Memorandum

Date: June 3, 2024

Re: Re-submittal of Site Plan, 9610 and 9630 Universe Boulevard NW (PR-2020-004024/SI-2024-00648)

The following memo provides responses to staff comments for the Site Plan Administrative application heard on May 16, 2024. Staff comments are in italic followed by the Applicant responses.

LS 101

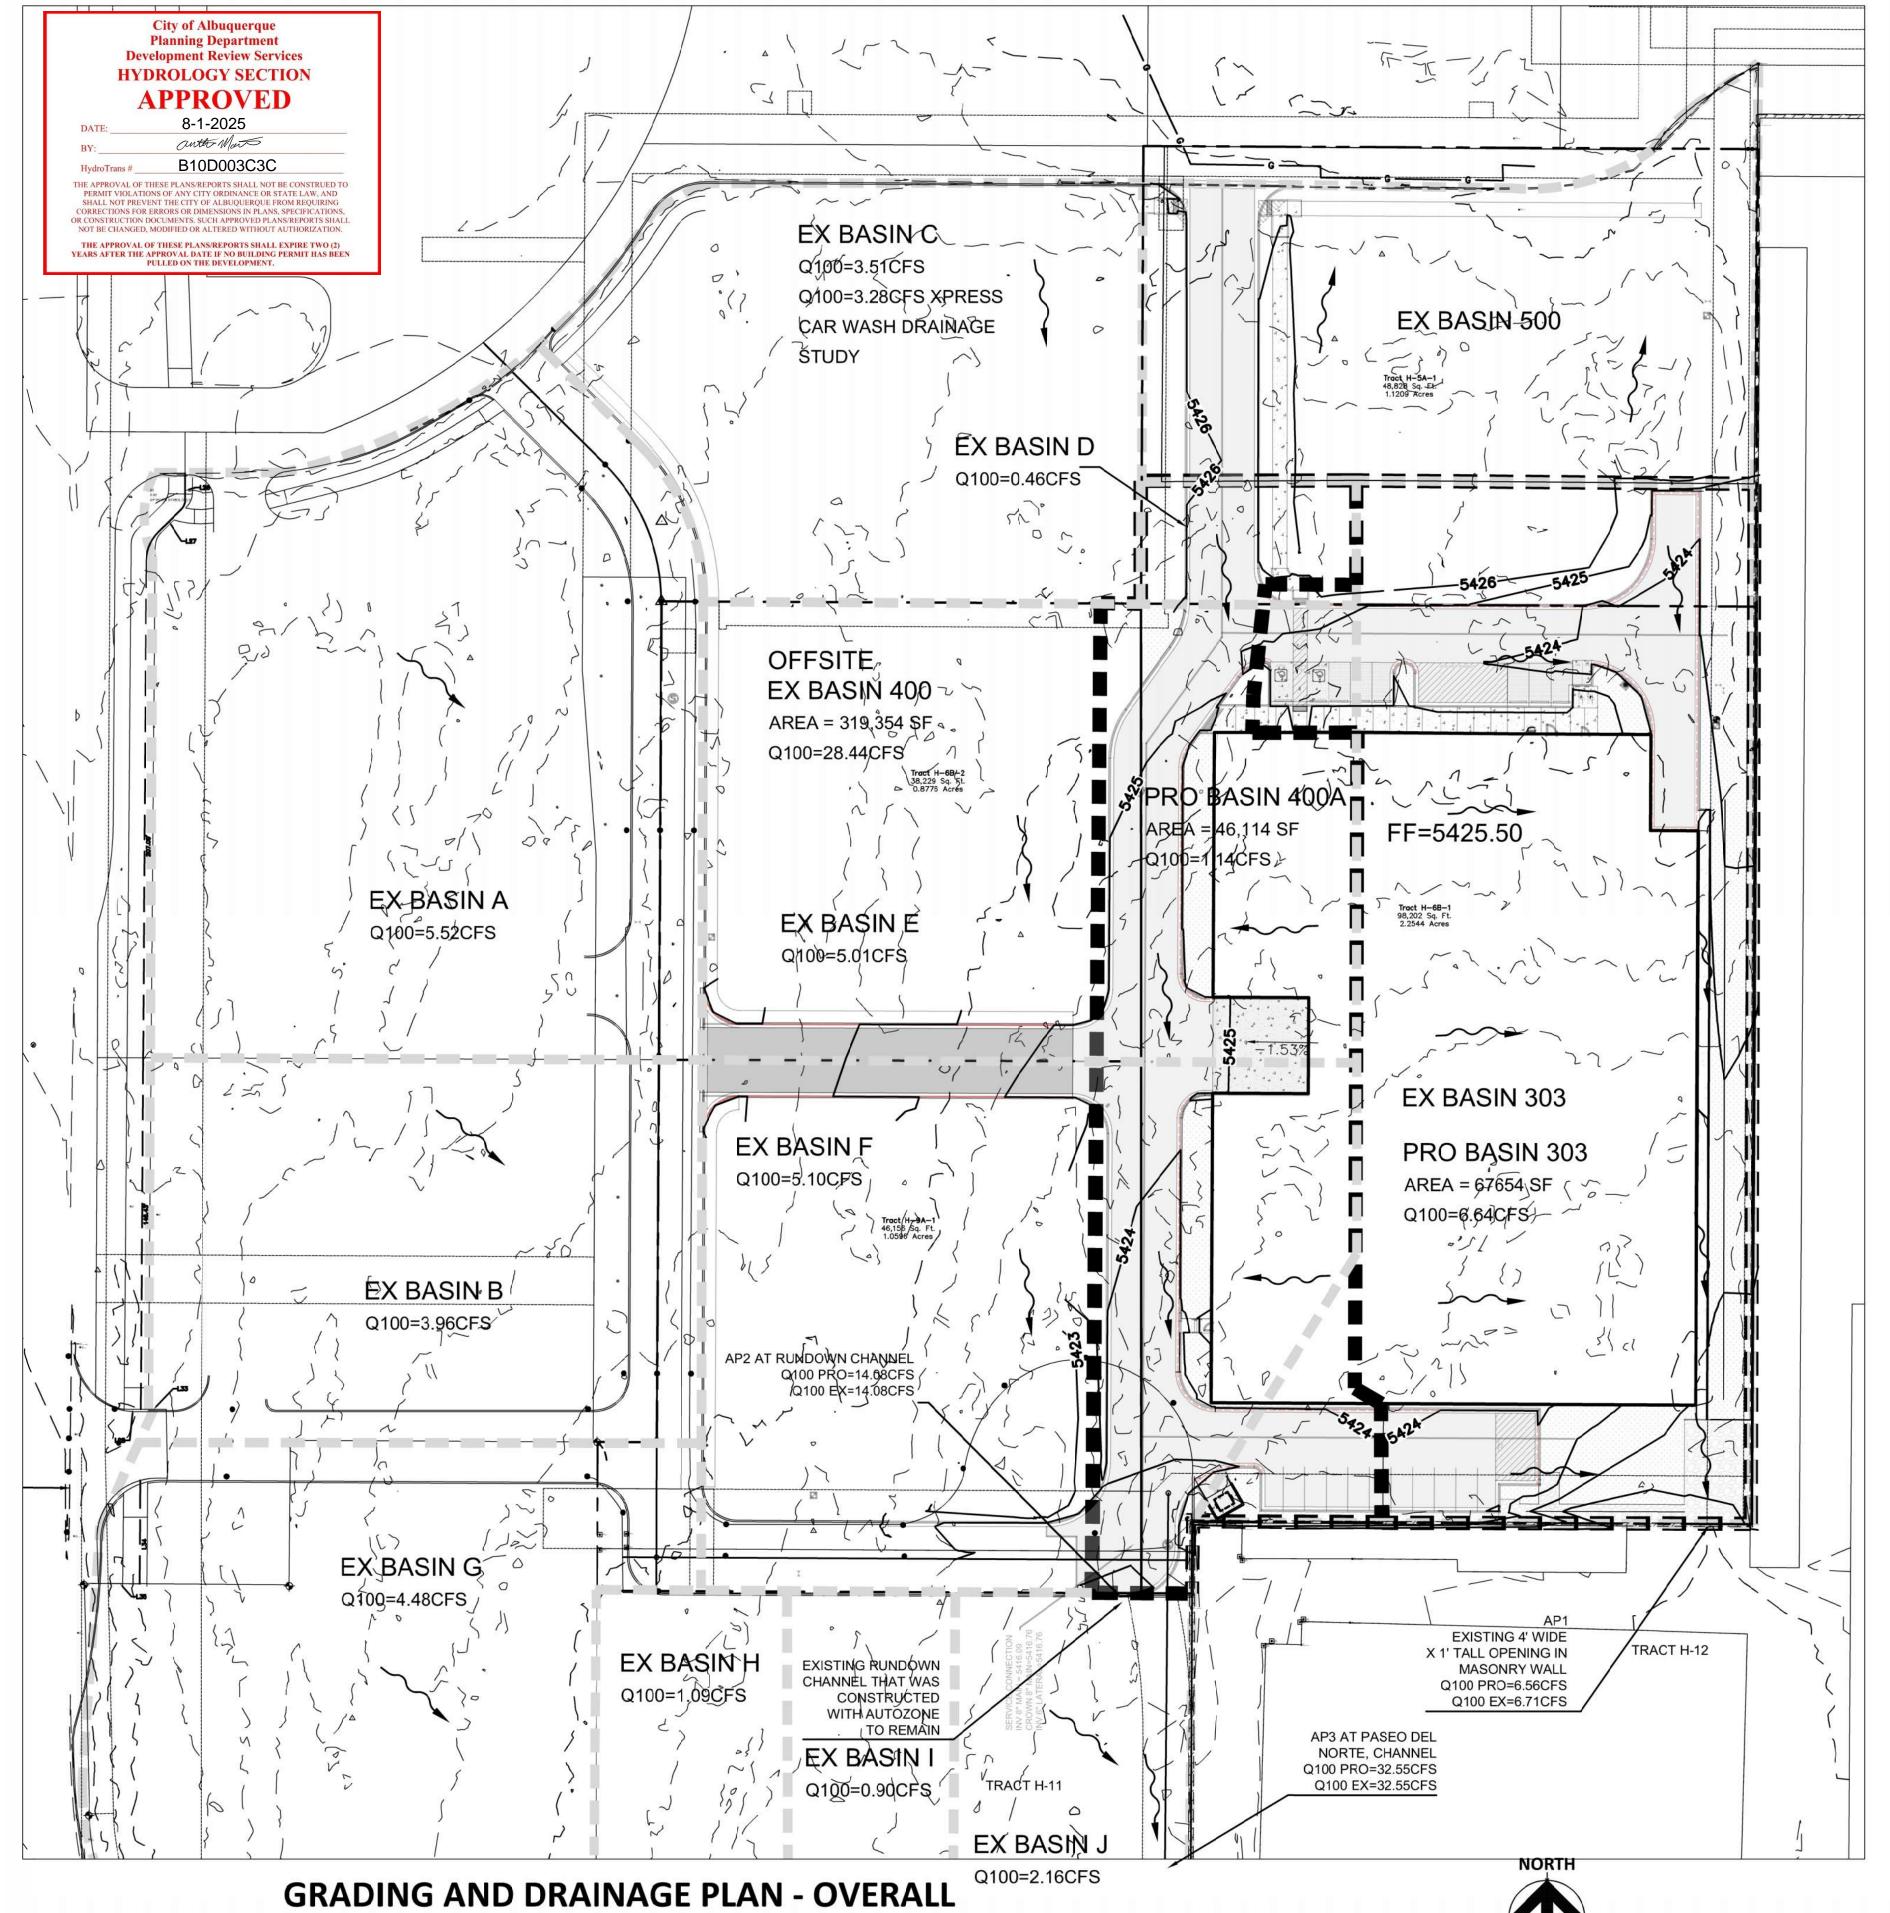
*Per 5-6(C)(2)(a) a minimum of 15% of the net lot area of each development shall contain landscaping. Those calculations are included in the submittal. In a resubmittal explain/demonstrate how all relevant sections within 5-6 are being met. Including but not limited to 5-6-C General Landscaping, 5-6-C-2 Minimum Landscape Area, 5-6-D Required Street Trees, 5-6-E-2 Minimum Landscape Area, 5-6-E-2 Development next to Low Density Residential, 5-6-F Parking Lot Landscaping, 5-6-G Equipment/Support Areas. * Include detail for pedestrian connections per IDO 5-3.*

Applicant Response: Agreed. Notes were added to the Landscape Plan for the above criteria. A pedestrian connection detail was added to the Landscape Plan showing landscape at the pedestrian connection into the site.
